Date: 6-9-21

Project: Zhang – Deck replacement
Site Address: 6408 E Mercer Way – Mercer Island, WA
Permit No: 2012-021

This submittal is in response to the correction requests by reviewers listed above.

SHEET NO.
A0.1

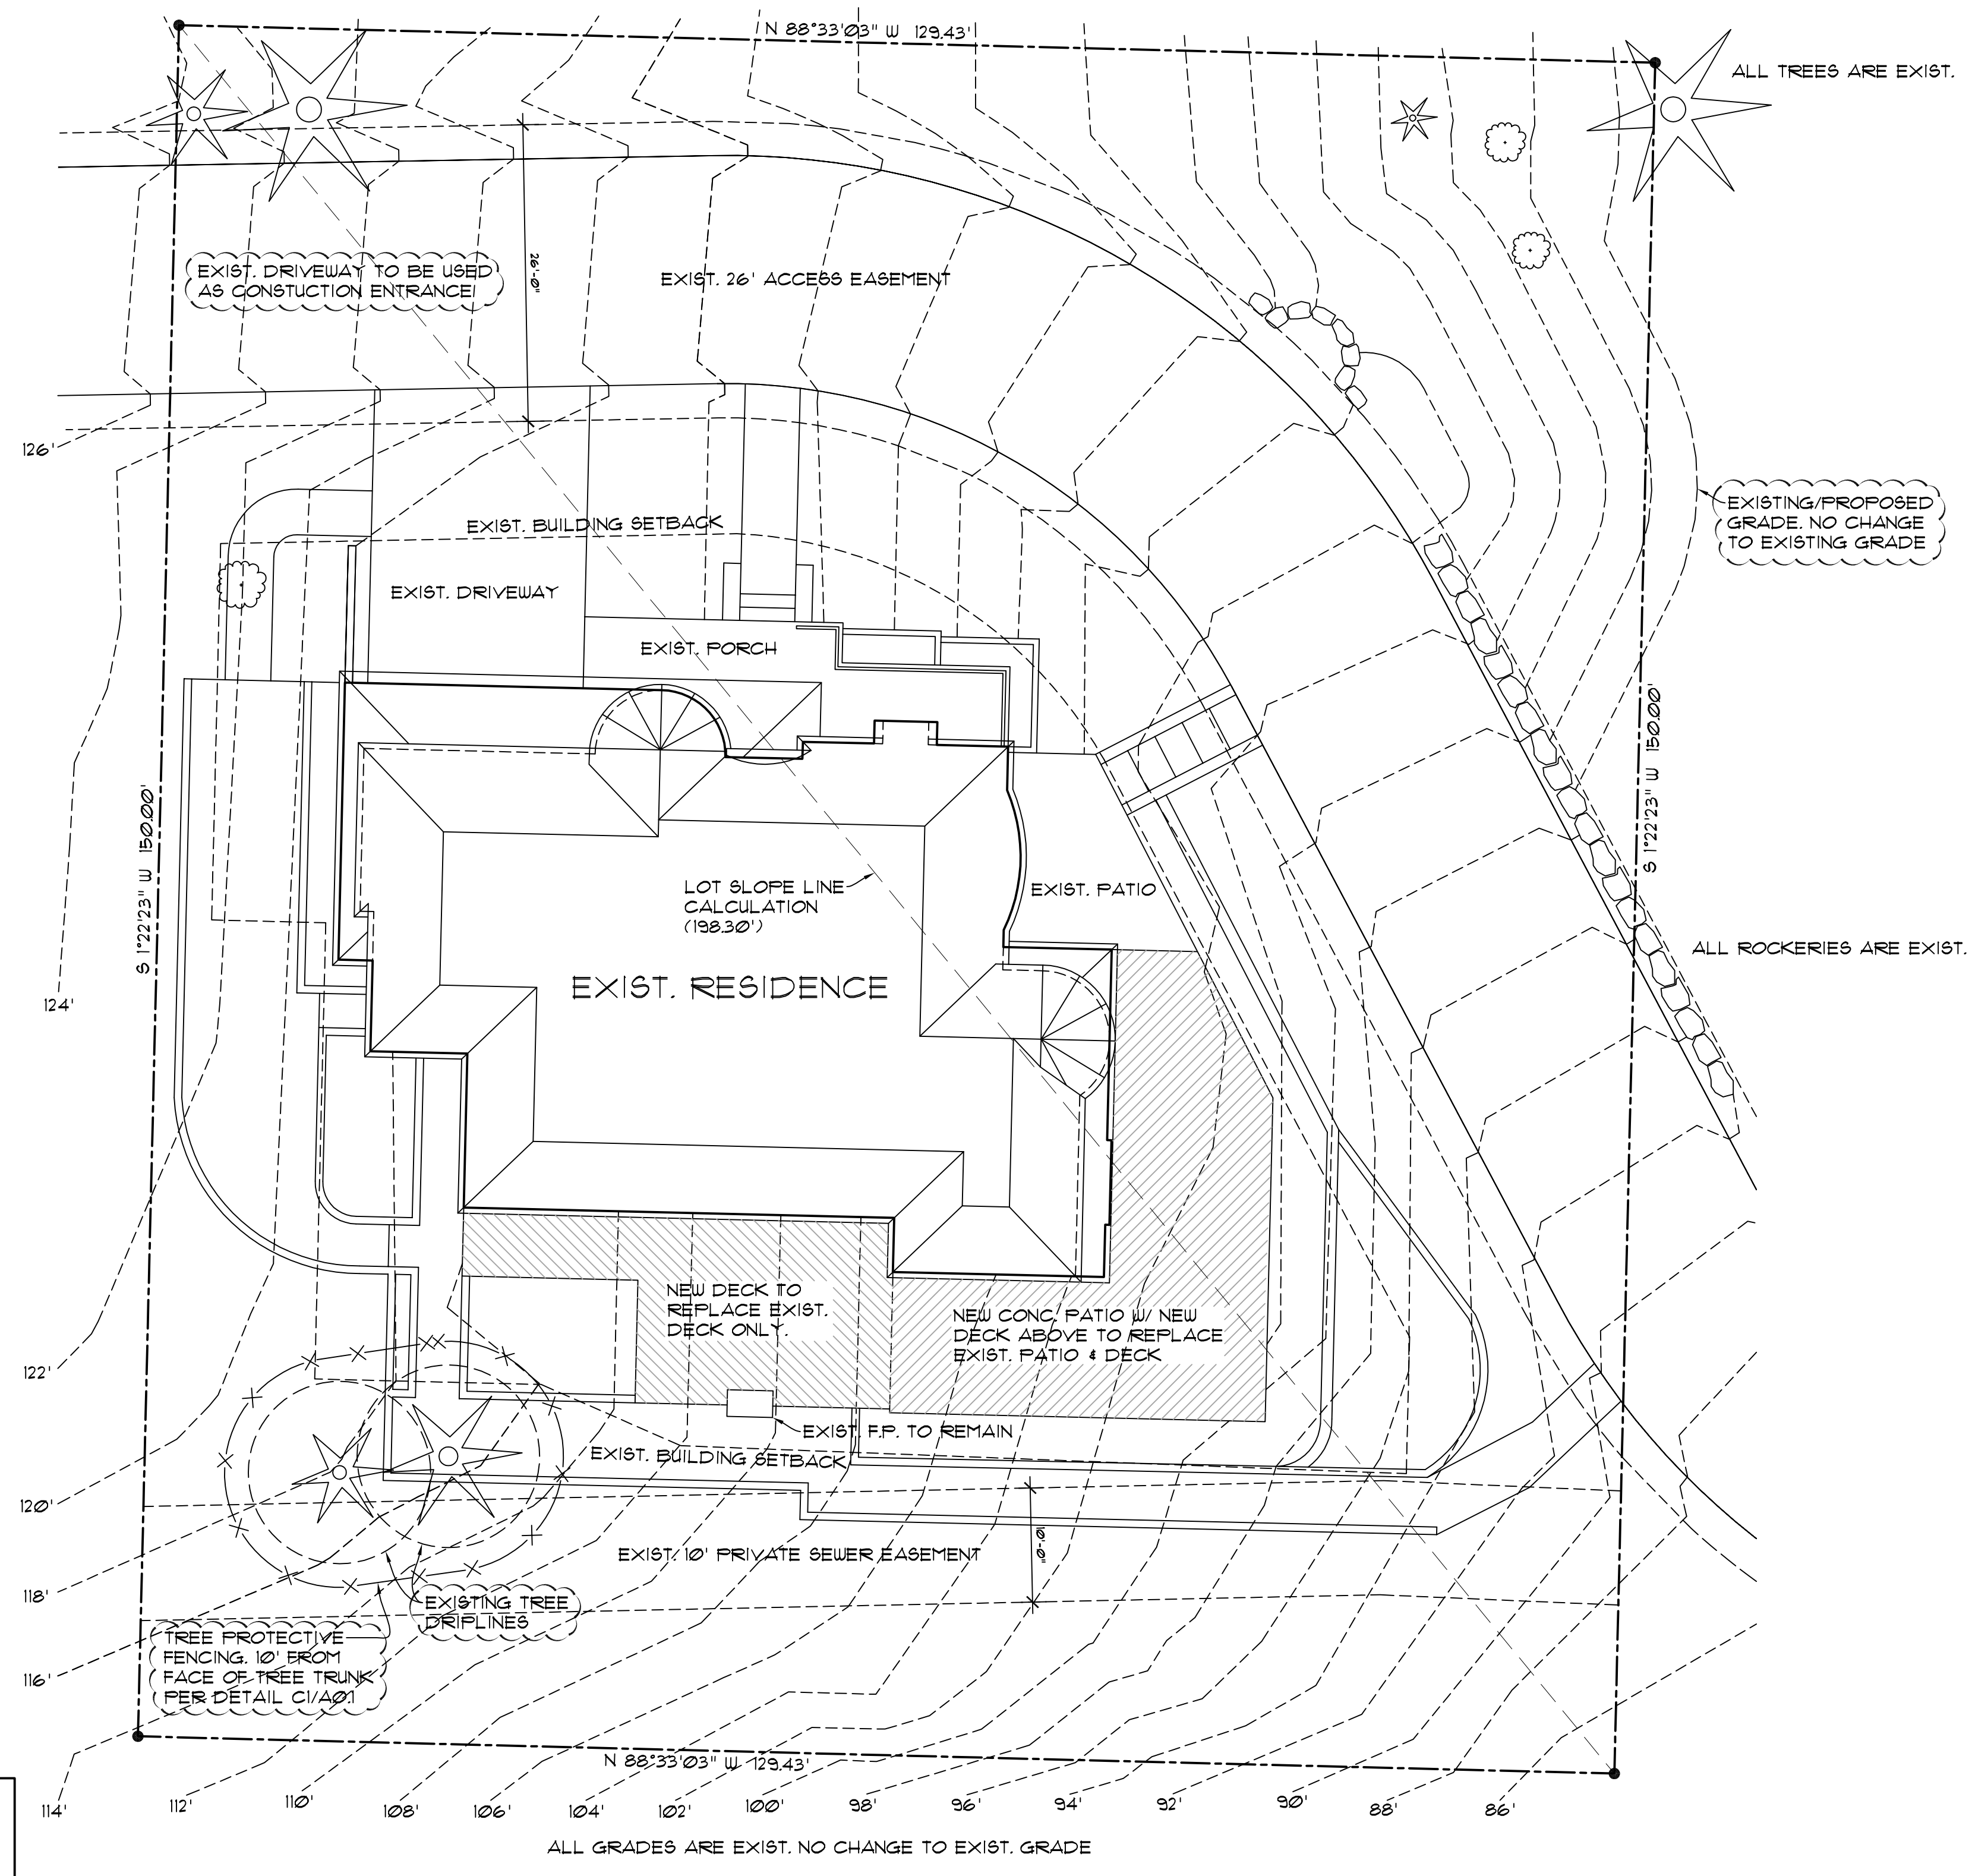
Trees

There are no significant trees being impacted for this project. However, we are now showing tree protection fencing around the closest trees to the work area.

LOT COVERAGE & HARDSCAPE CALCULATIONS

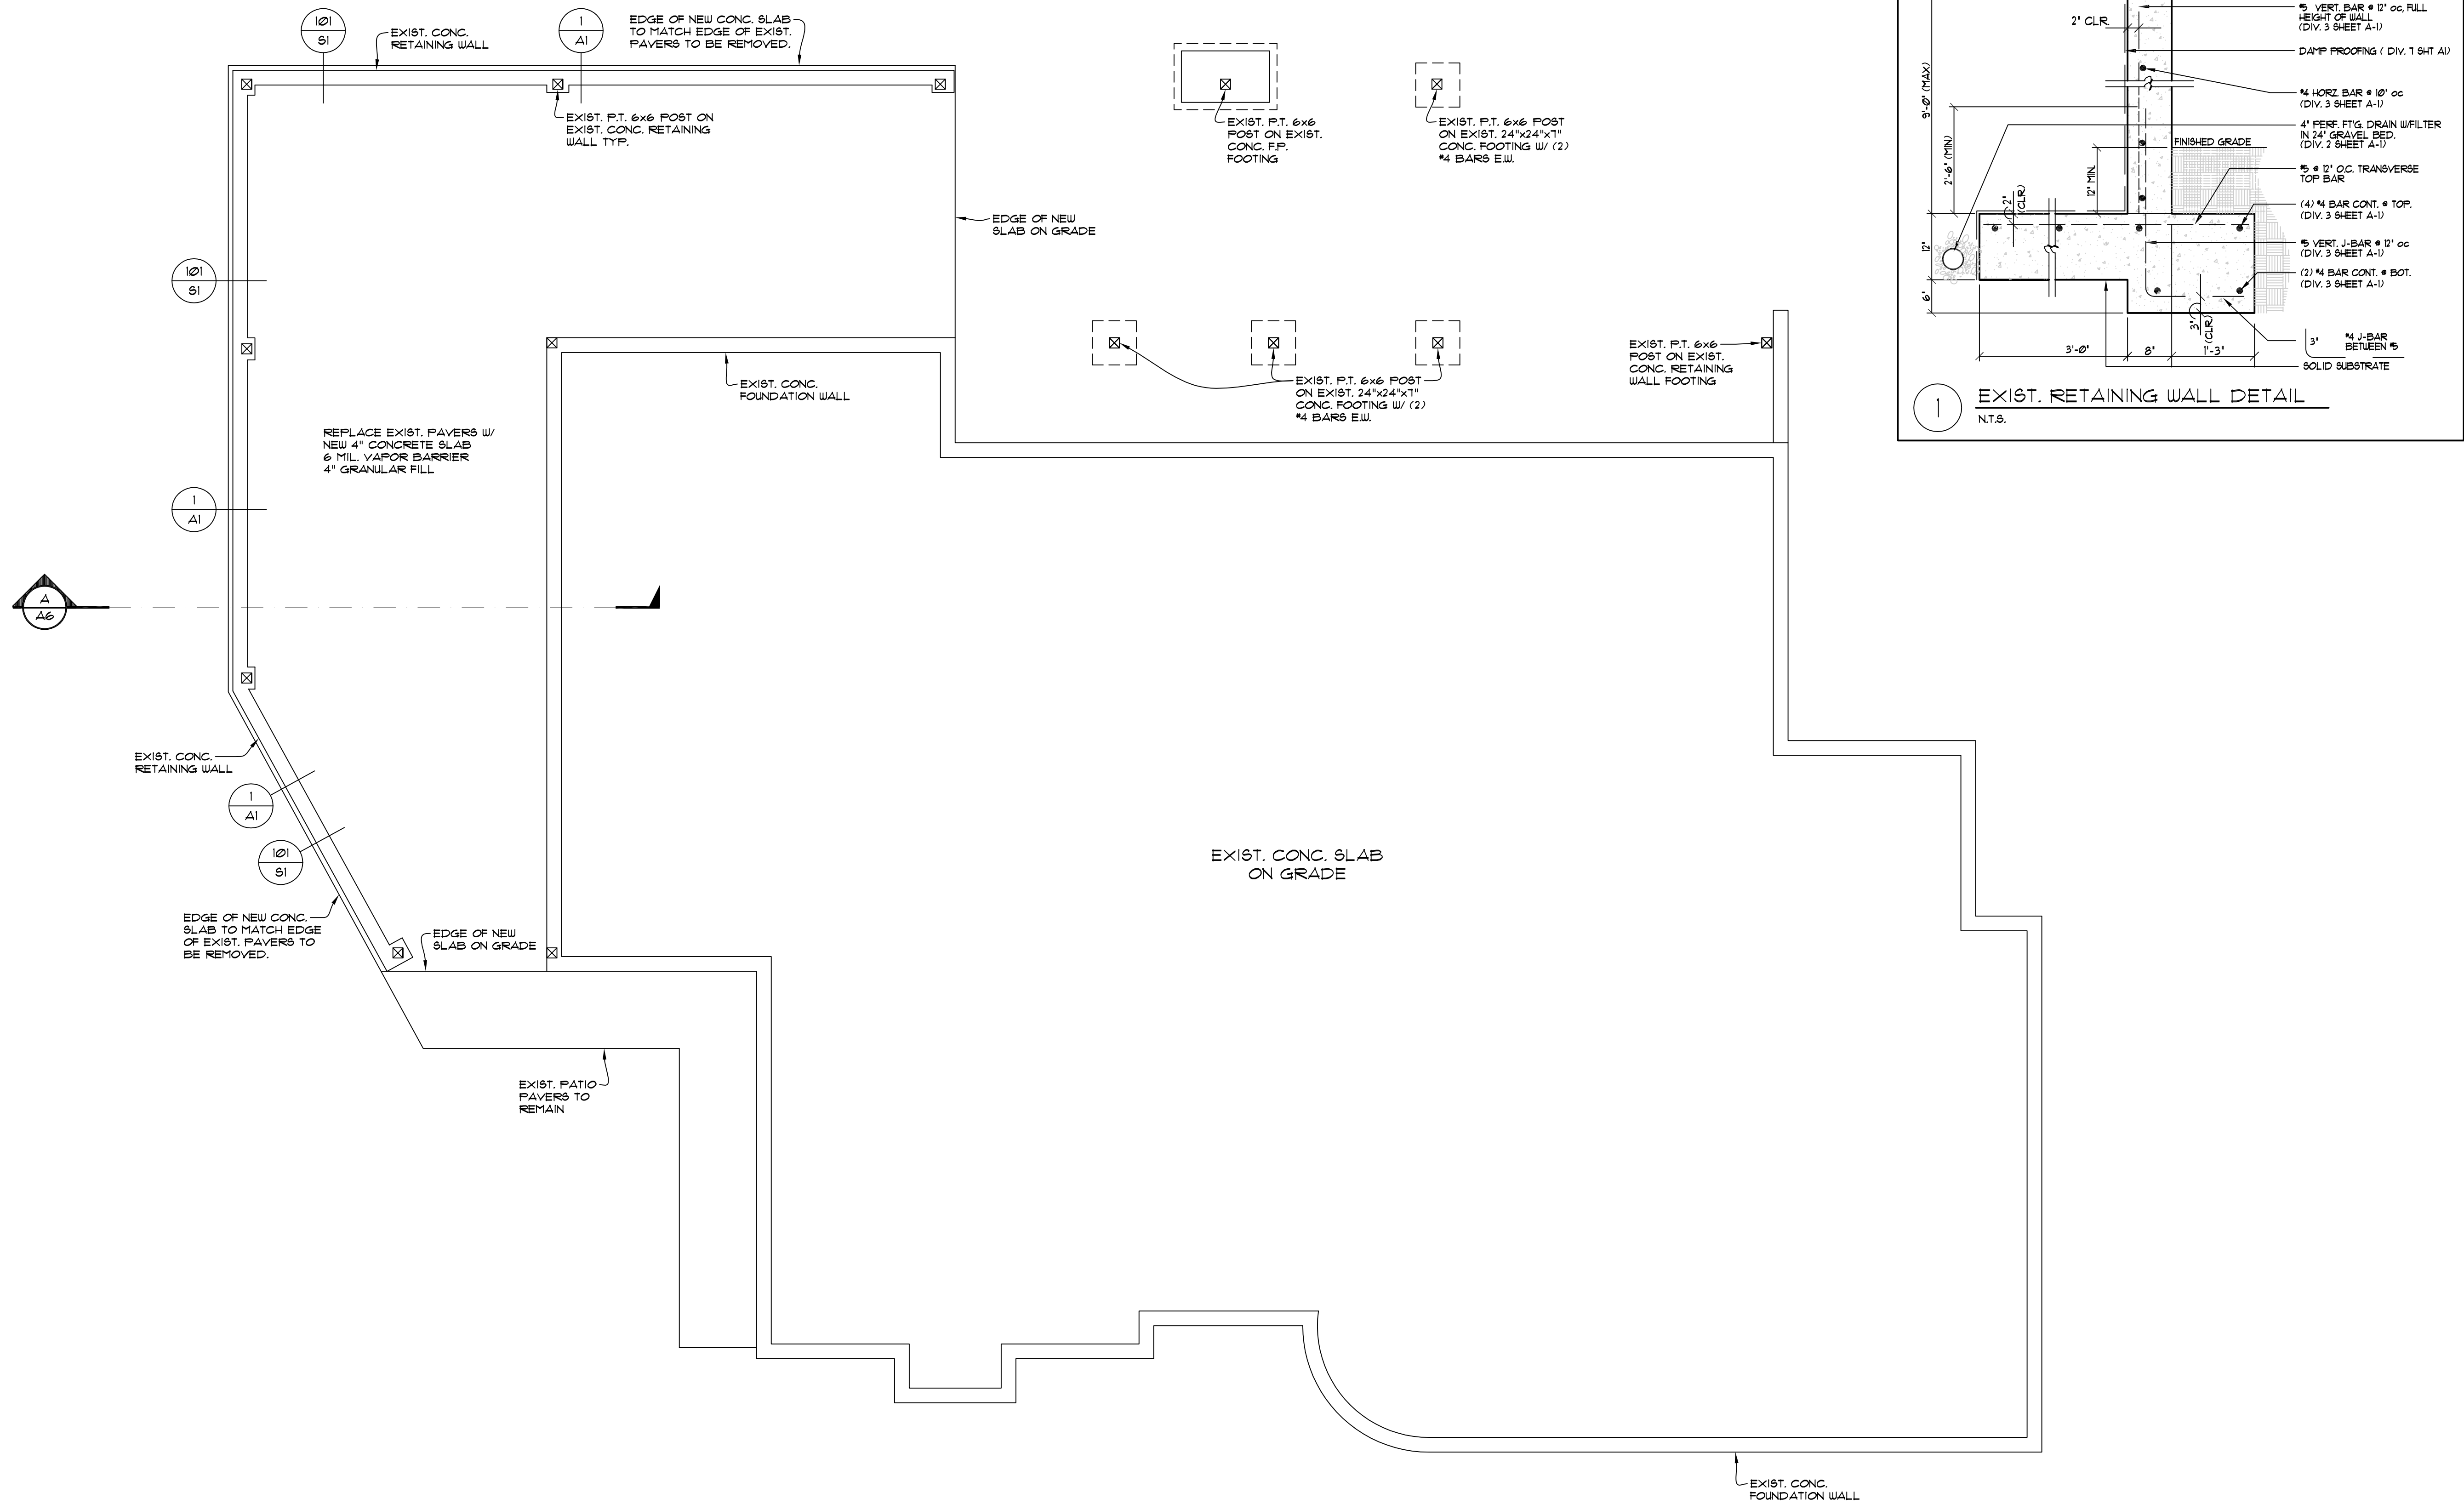
Hardscape and Lot Coverage

We are converting 753 sf of existing hardscape (slatted deck) into lot coverage area (waterproof deck over patio below). Resulting lot coverage is within limits. Existing hardscape is legally non-confirming, but we are only removing hardscape area.
